February 3, 2024

Development Review Board  
City of Albuquerque

**Re: Prelim/Final Plat for Minor Subdivision of Lots 5 and 6, Block 2 of Apodaca-Griego & Rafael Addition**

DHO Determination from R.O.W. Width Note

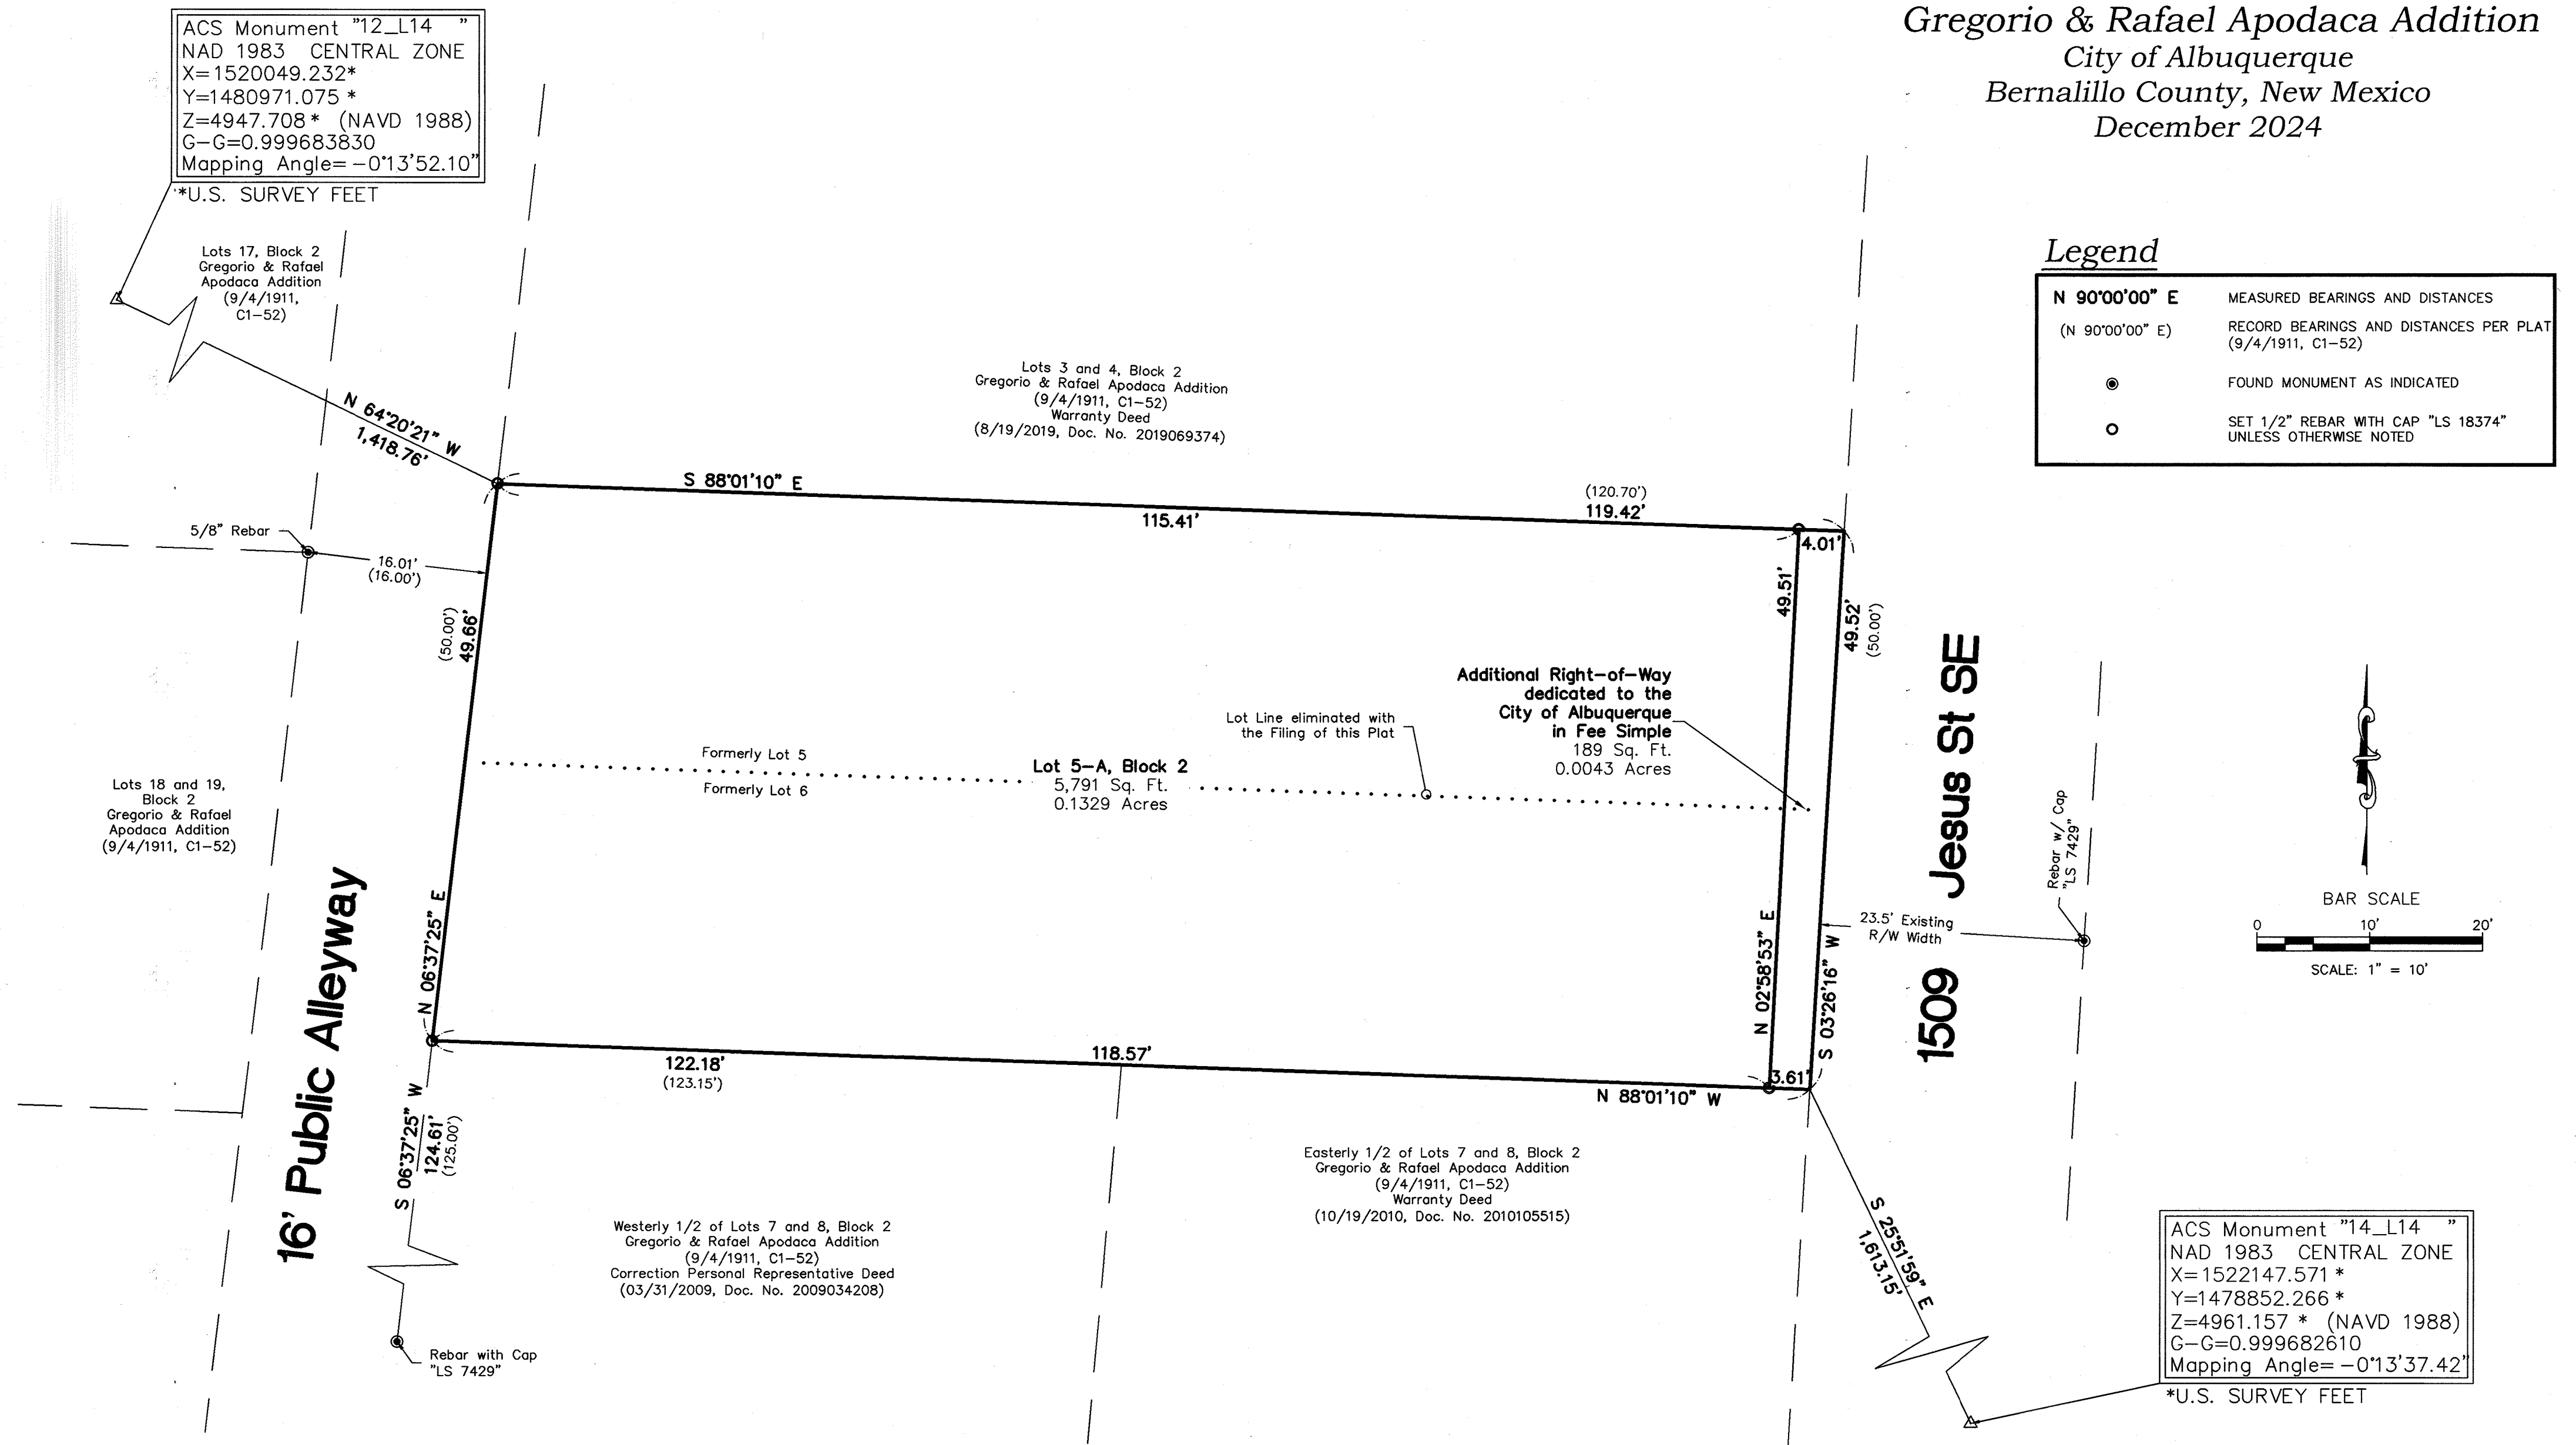
2. The alley at the west side of the property is 16' where alleys are required to be 20'. Right-of-way dedication is required. You may request a determination to keep the alley at its existing width

Noted, we request a determination to allow the existing alleyway width to remain 16ft, given the existing fencing, walls, and other improvements which would make this historically developed area a burdensome and anomalous area if widened.
